## Application for a Non-Material Amendment Following a Grant of Planning Permission

Demolition of three agricultural silos and barn and erection of a two-bedroom dwelling with associated amenity space and parking spaces

3/22/1728/FUL

Revisions to proposed windows on approved plans from Aluminium to UpVC Casement Windows RAL 7016

**Drawing No:** NB0921 / 202 / C

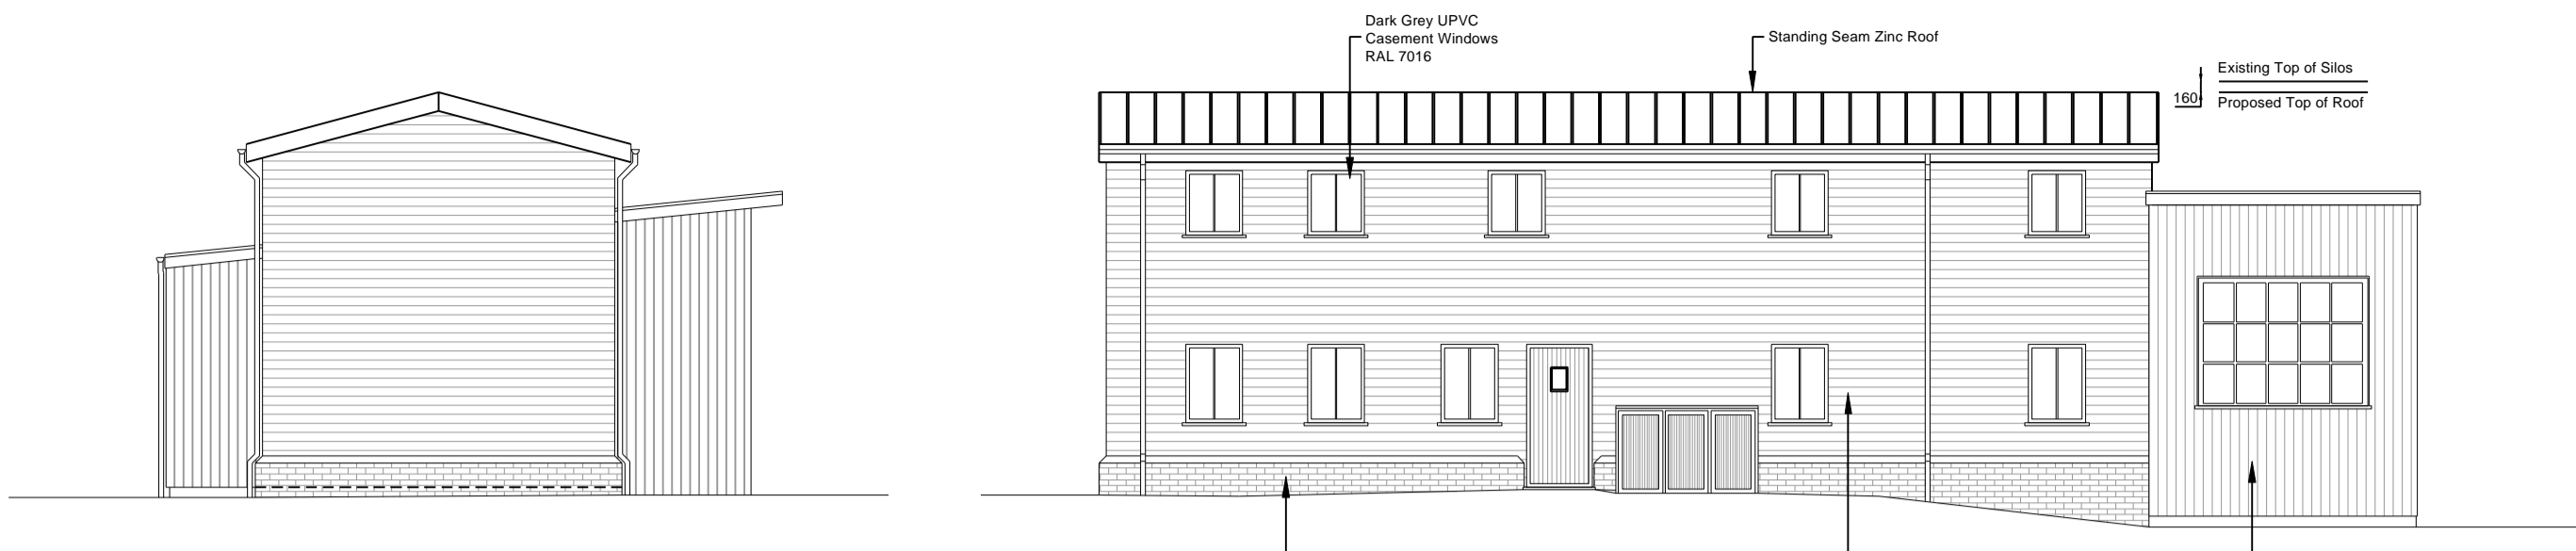
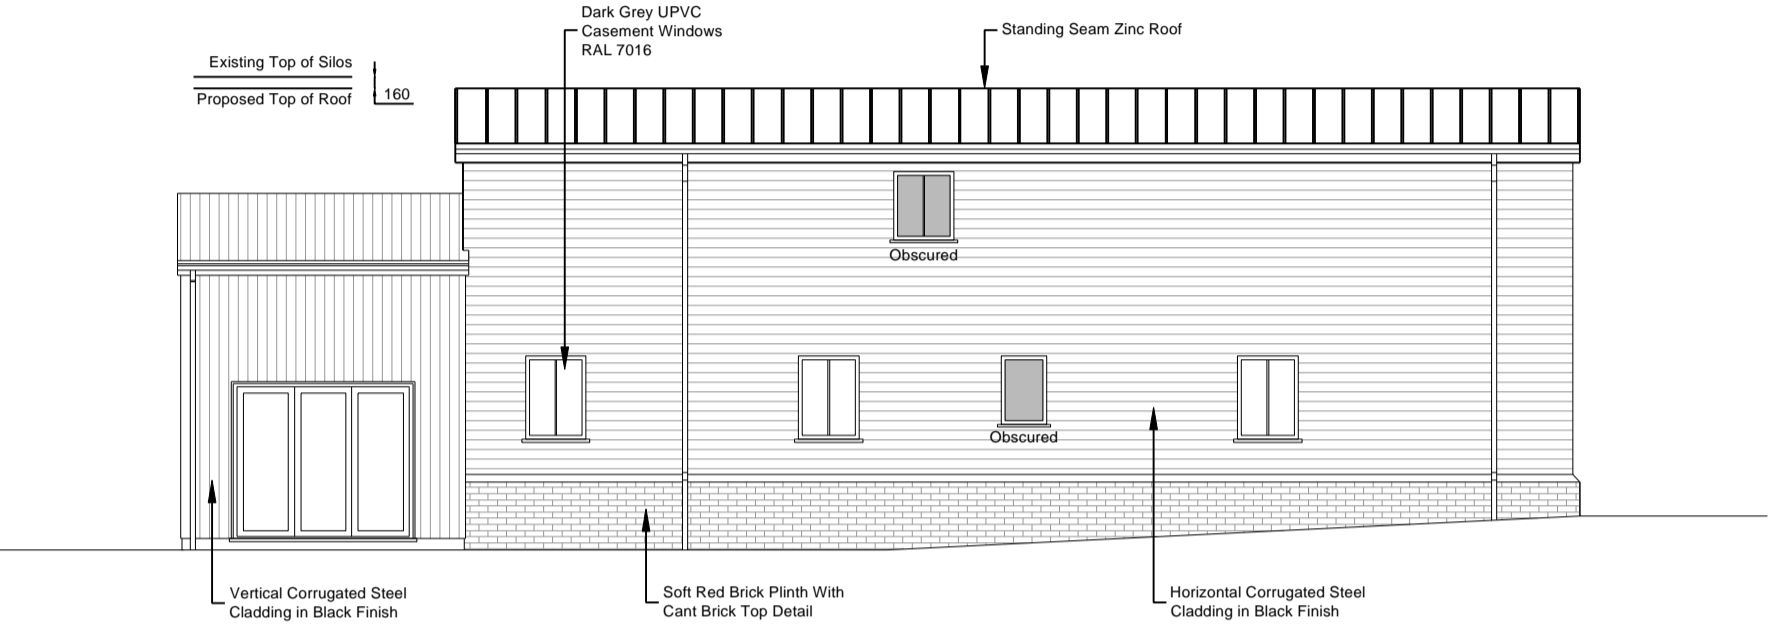
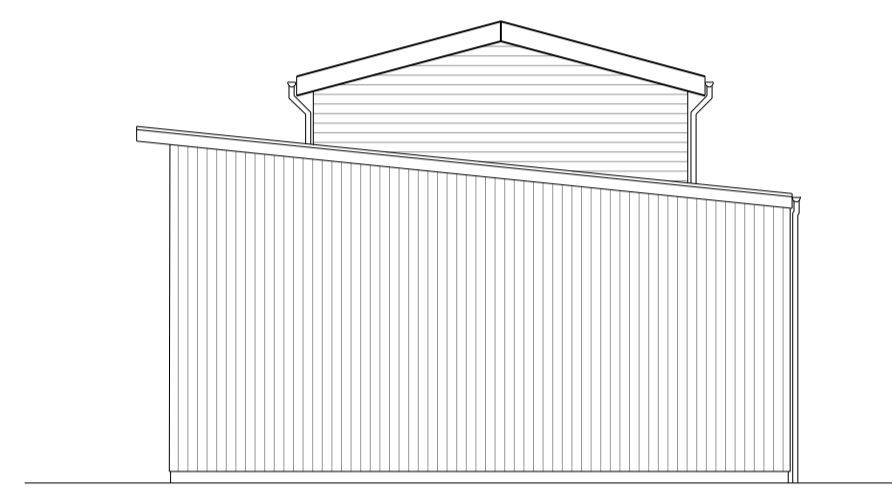
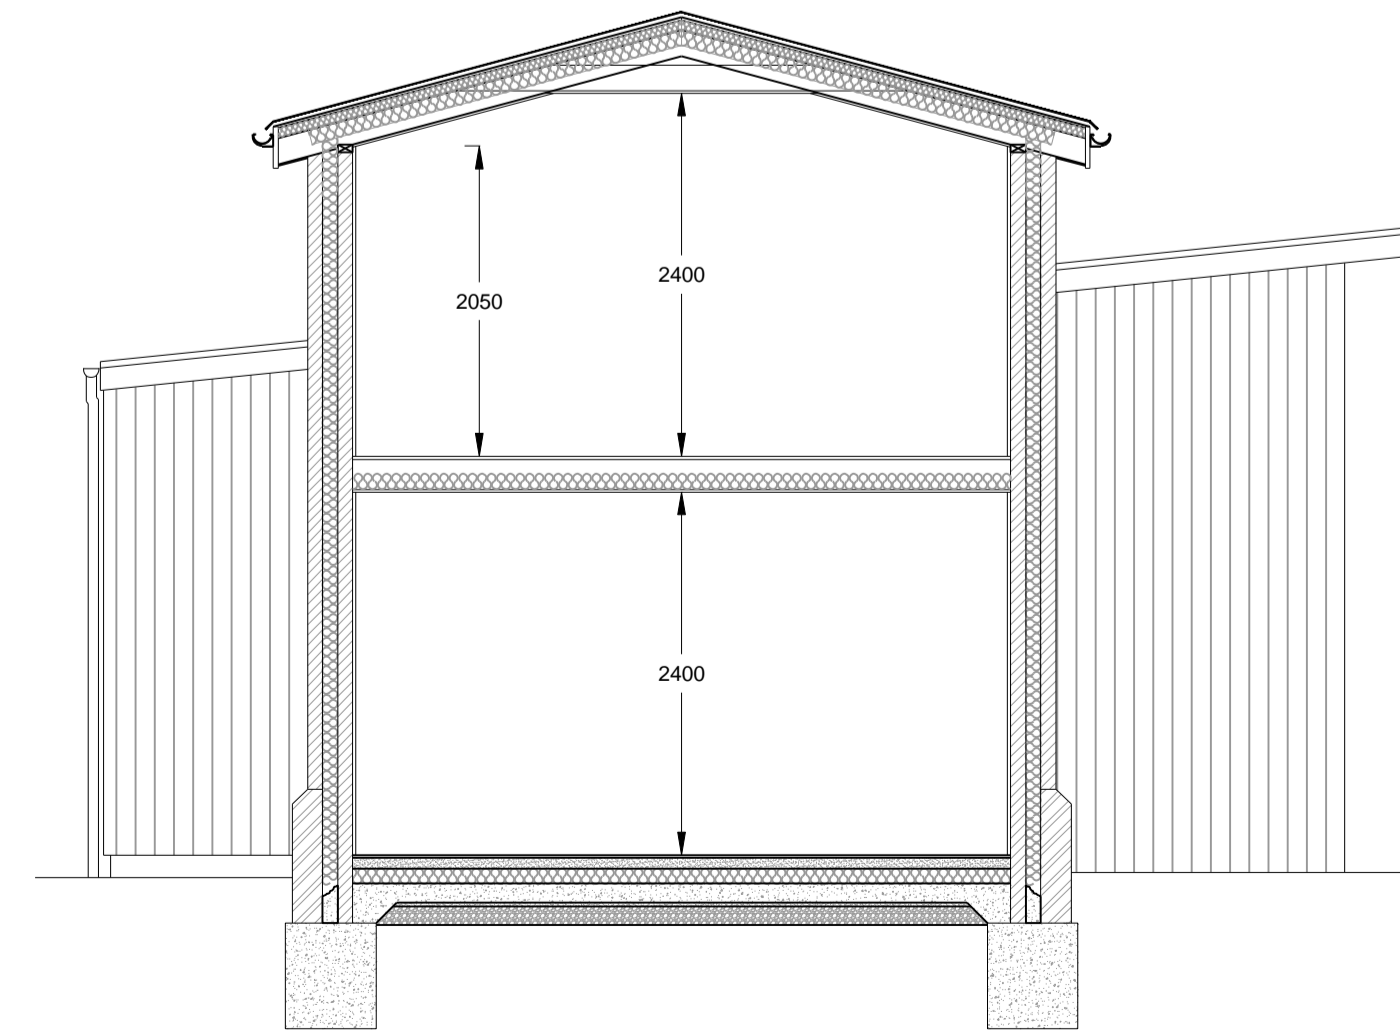
for energy efficiency

NB0921/202 Rev C
